From: Bloomer, David <David.Bloomer@lancashire.gov.uk>
Sent: 05 September 2018 09:49
To: Adrian Dowd
Cc: LHS Customer Service; planning
Subject: app3/2018/0745 Susie Cottage Rimington

site and roof plan

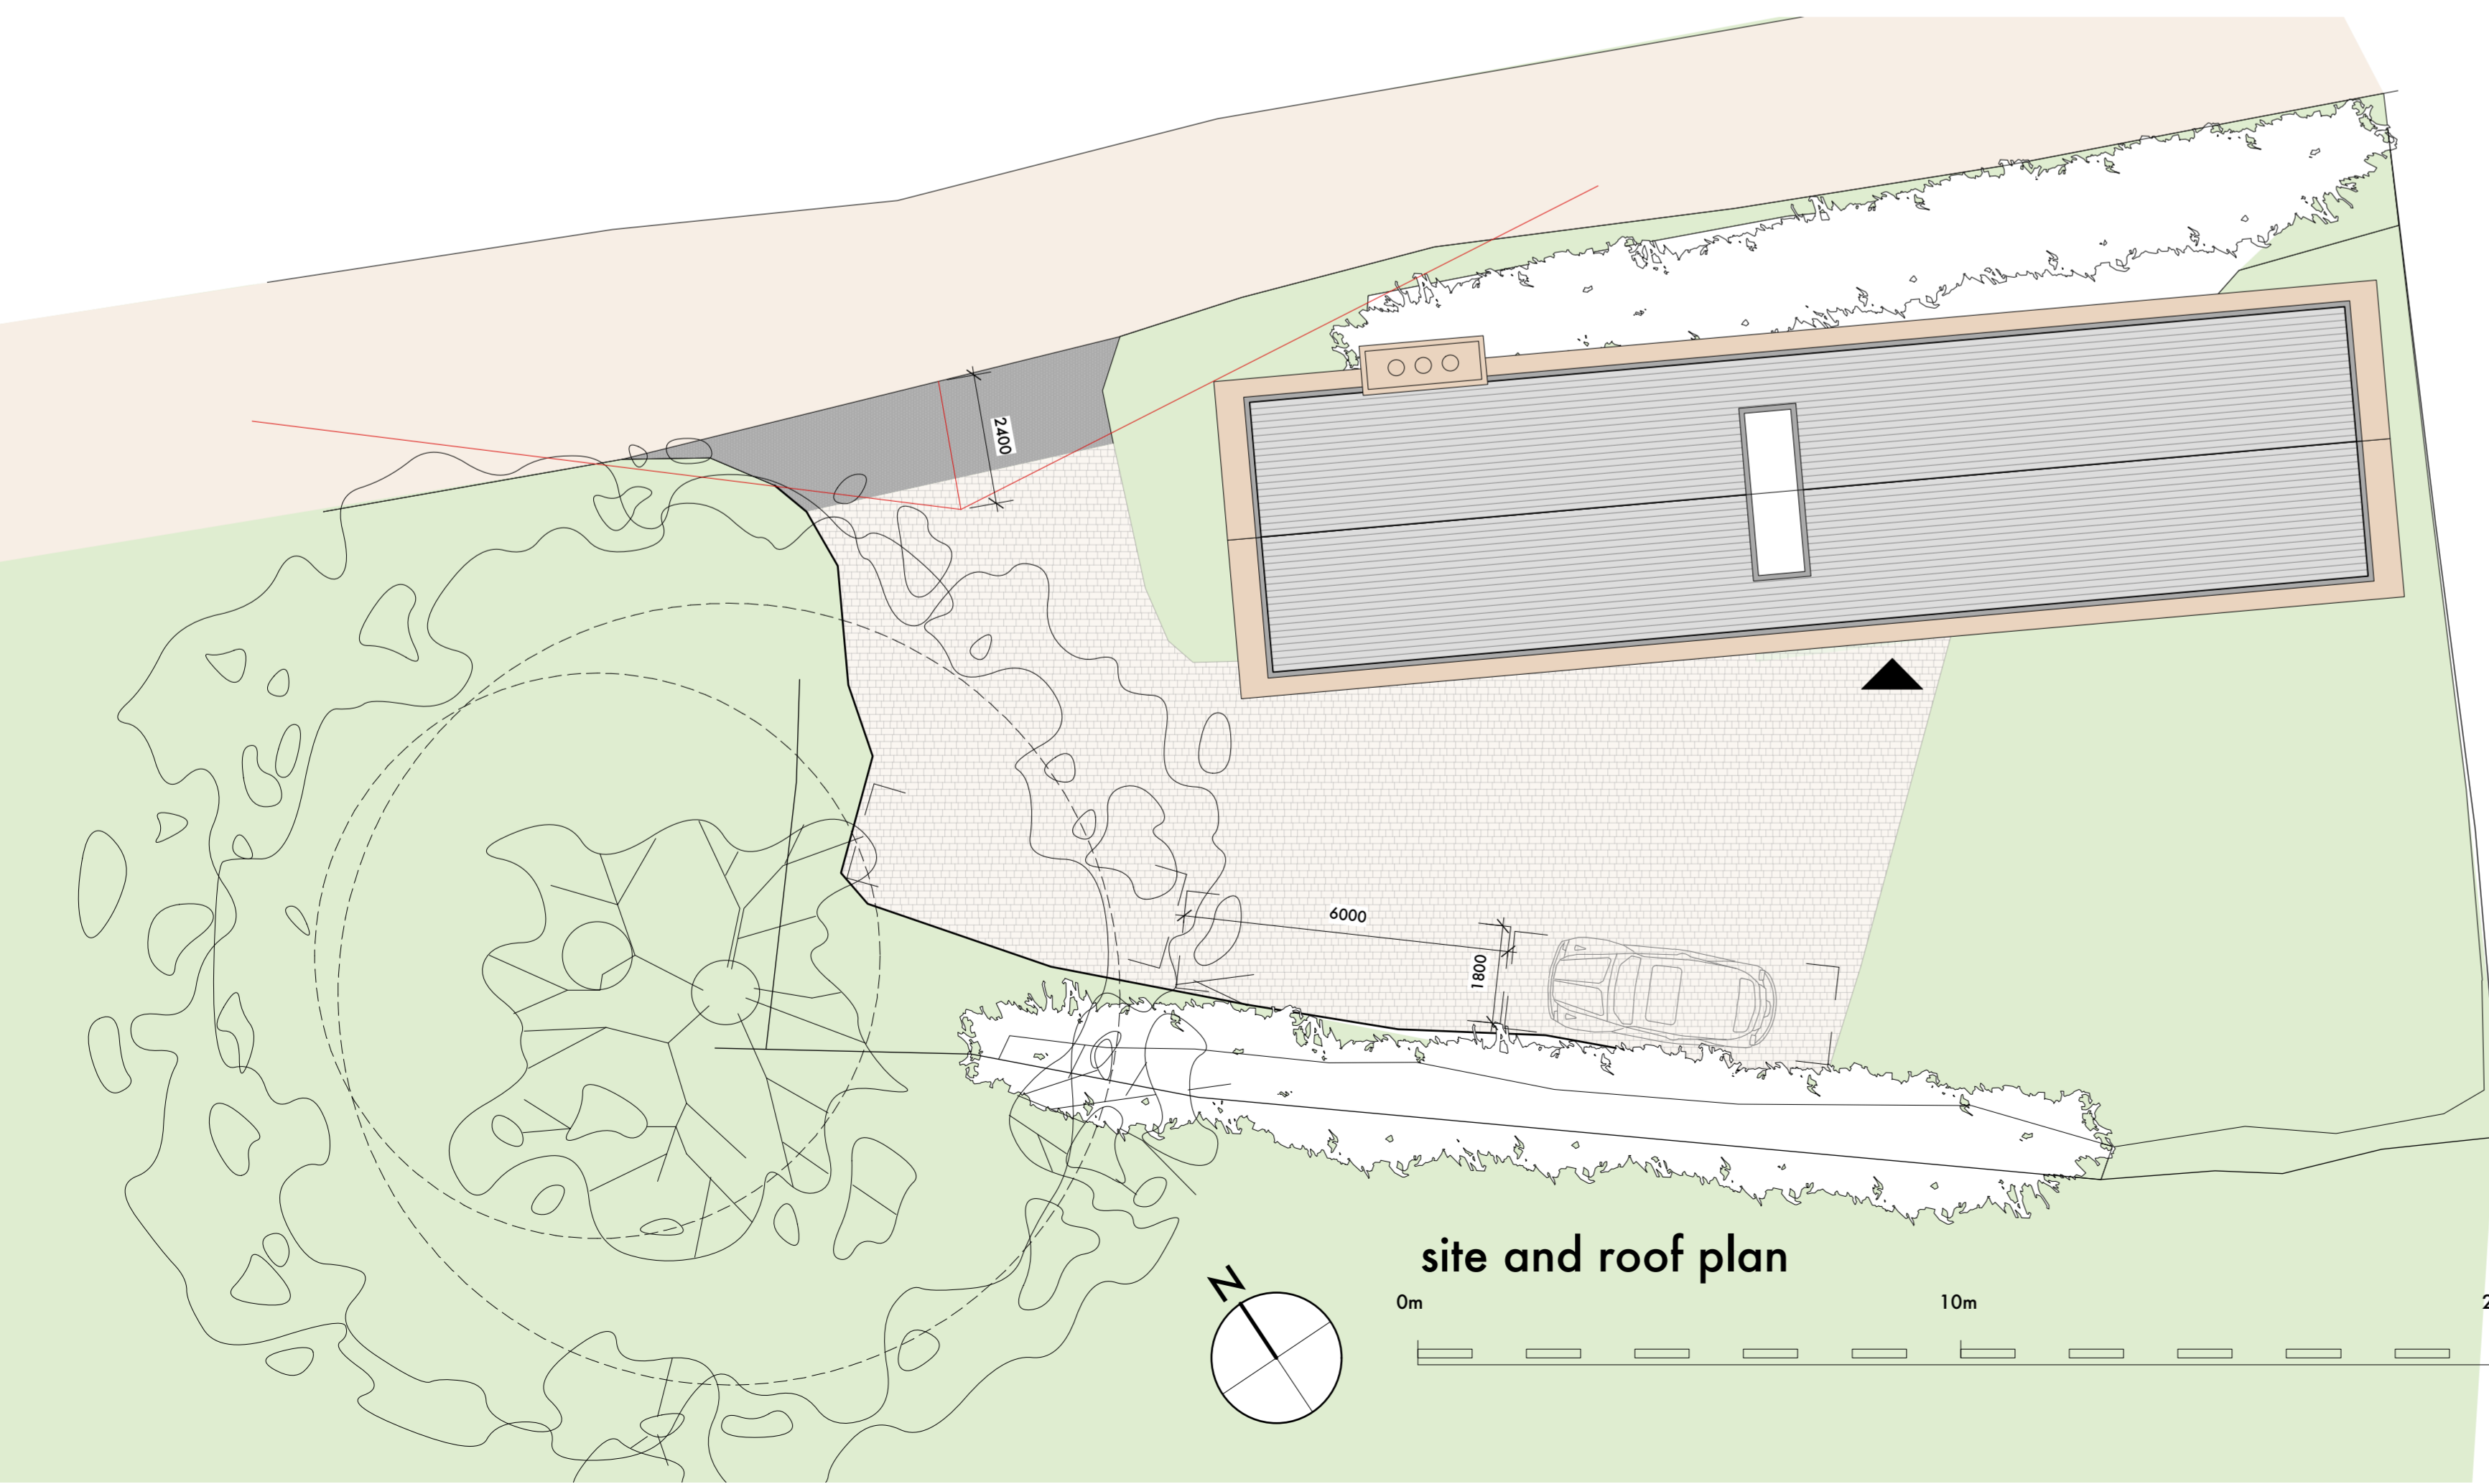
1 Before the development hereby permitted becomes operative, the existing hedge and vegetation on the highway frontage of the site to Rimington Lane shall be reduced to and be permanently maintained henceforth at a height not greater than 1m above the crown level of the carriageway of Rimington Lane.
Reason: To ensure adequate visibility for the drivers of vehicles entering and leaving the site.

4. Any hard standing for vehicle parking should be appropriately paved in tarmacadam, concrete, block paviments, or other approved materials for a distance of 5m back from the edge of the carriageway Reason: To prevent loose surface material from being carried on to the public highway thus causing a potential source of danger to other road users.
